WEST SUSSEX COUNTY COUNCIL CONSULTATION

TO:	Arun District Council FAO: Andrew Wood
FROM:	Highways, WSCC
DATE:	14/11/2018
LOCATION:	12 West Drive Ferring BN12 5QZ
SUBJECT:	FG/196/18/PL Demolition of existing detached dwelling & detached garage & construction of 1 No. new detached dwelling
DATE OF SITE VISIT:	N/A
RECOMMENDATION:	☒ Advice ☐ Objection ☐ Modification ☐ No Objection ☐ More Information ☐ Refusal
S106 CONTRIBUTION TOTAL:	£N/A

Proposed Ground Floor Plan
Scale 1:100

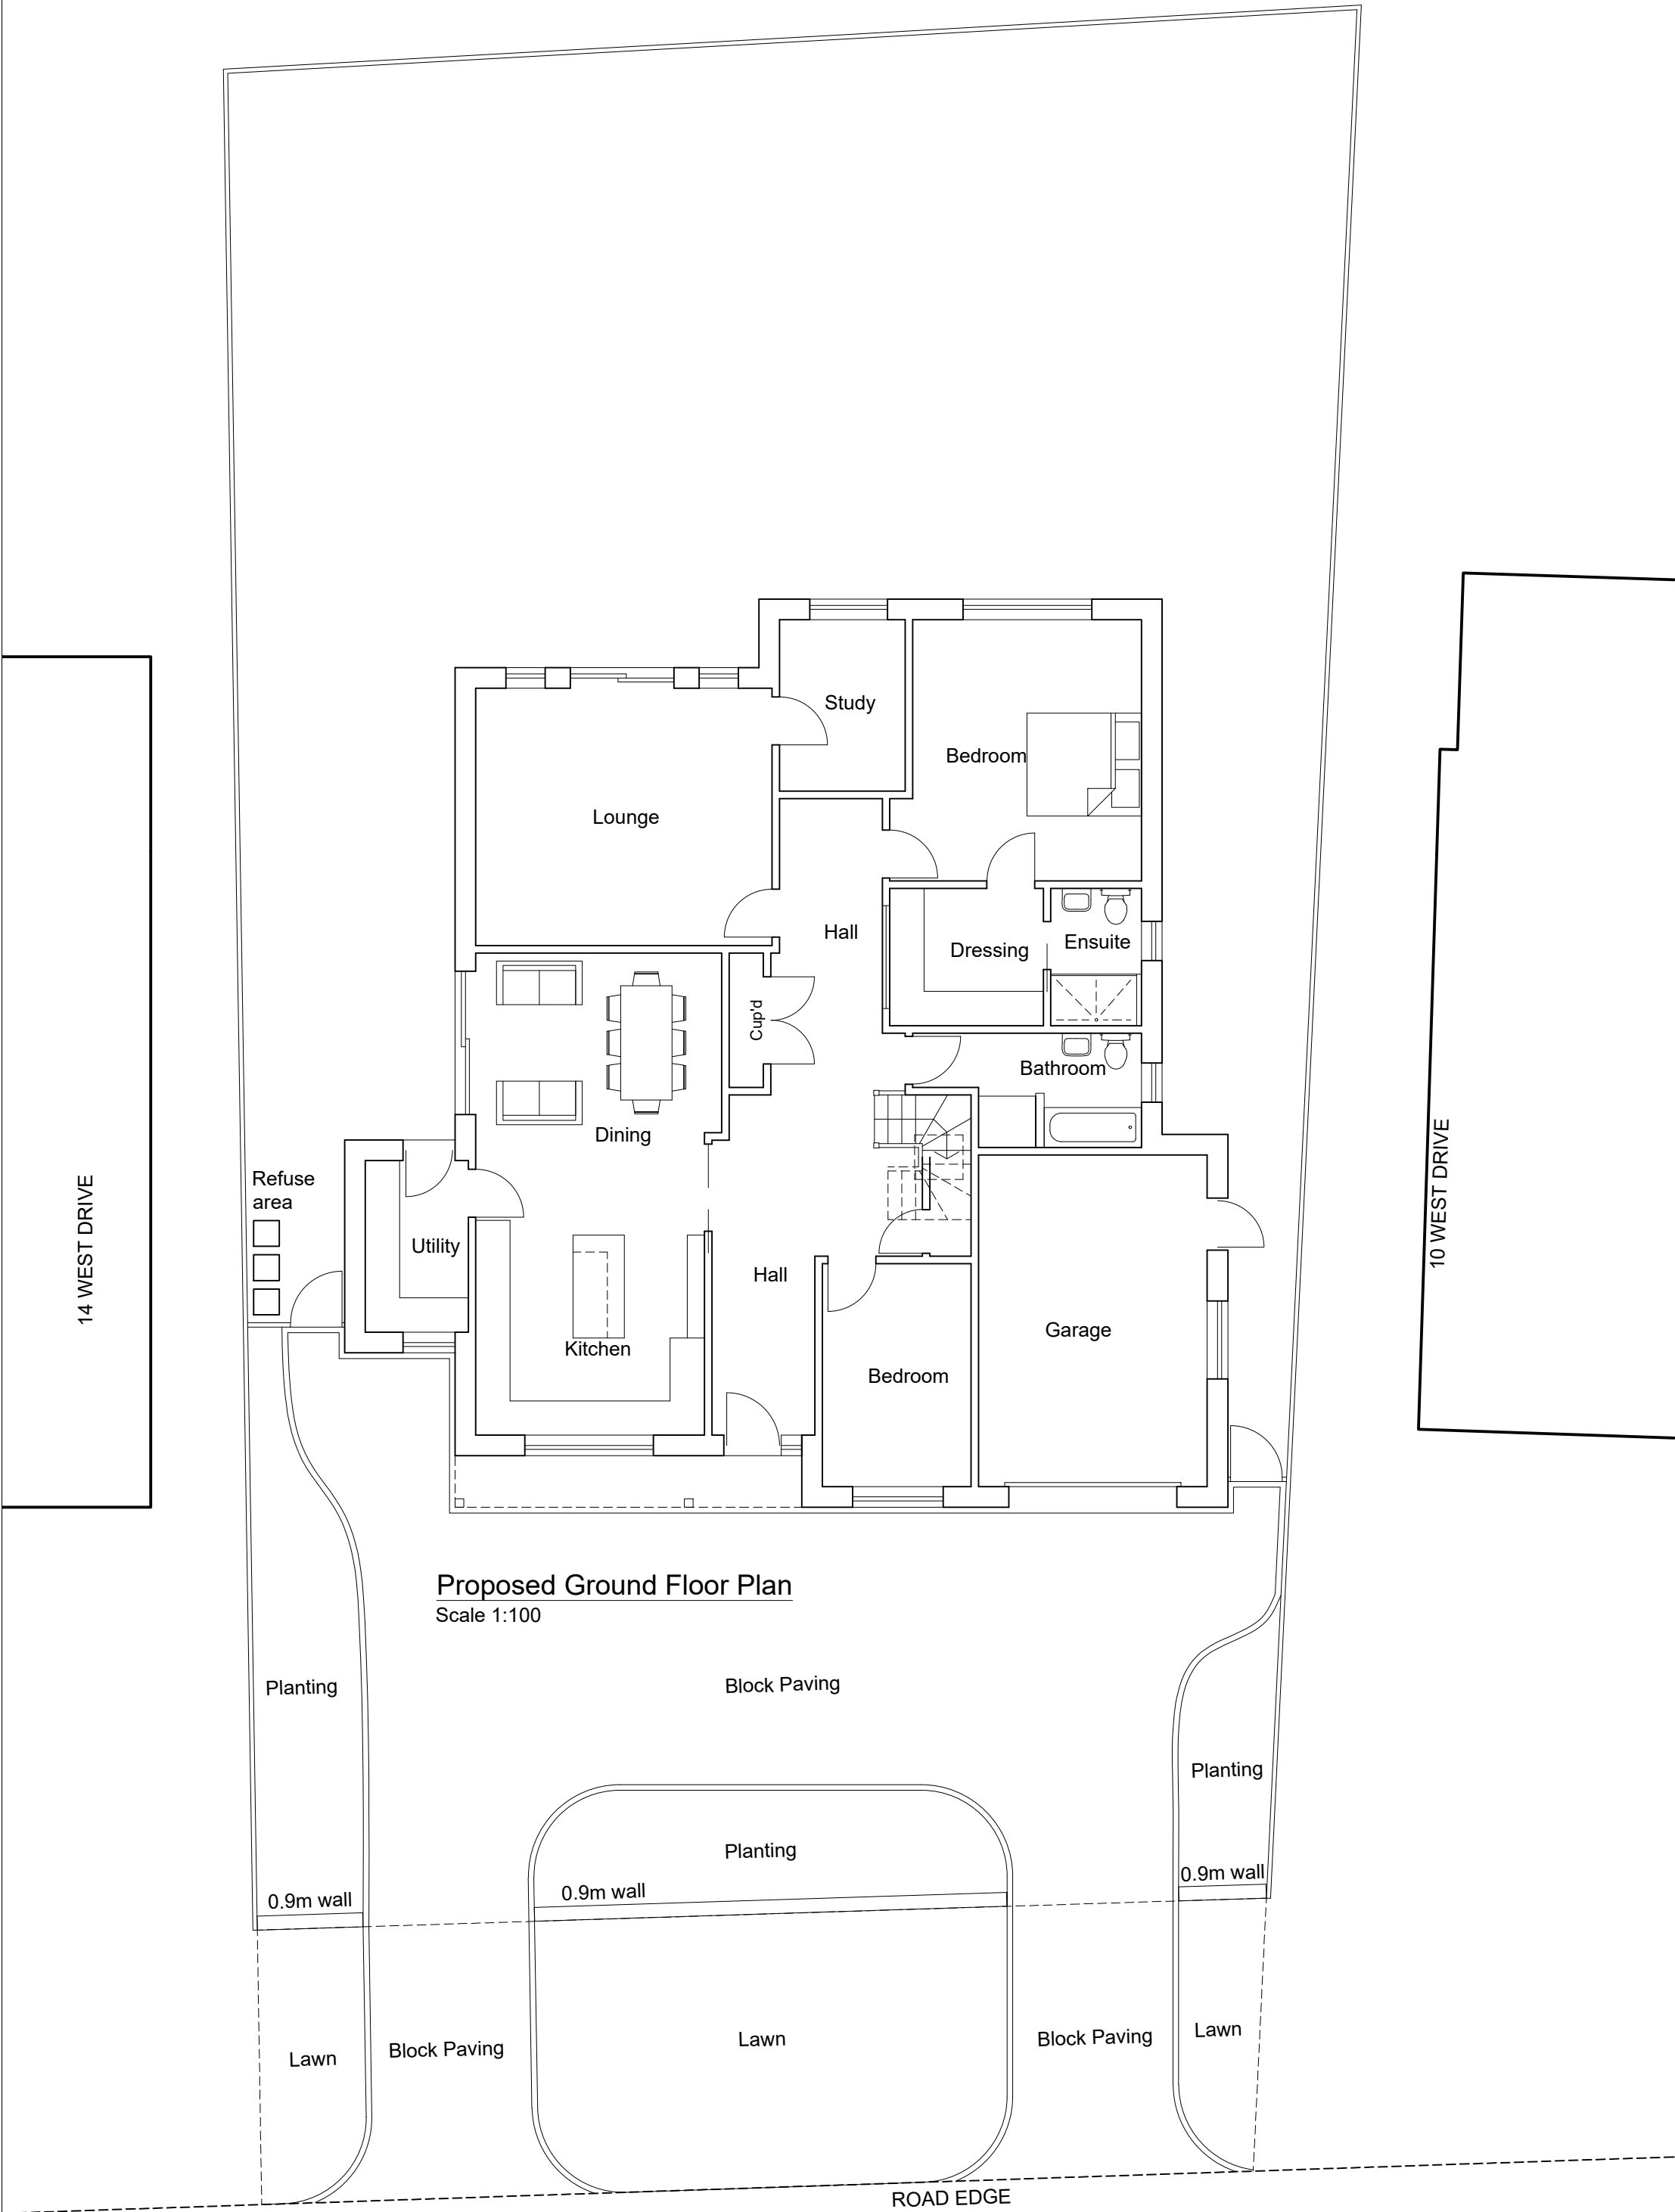
The proposed plans indicate that a single integral garage will be provided on site. The proposed plans demonstrate internal dimensions of 4m x 5.8m. In order to be counted towards parking provision for

the dwelling, the minimum internal dimensions should meet Manual for Streets guidance of 3 x 6m. The applicant is advised to consider increasing the proposed garage depth to meet these minimum internal specifications. However, this is not anticipated to cause a highway safety concern in this location. A parking layout plan has not been demonstrated; however there appears to be sufficient space on site to accommodate sufficient parking provision for the dwelling.
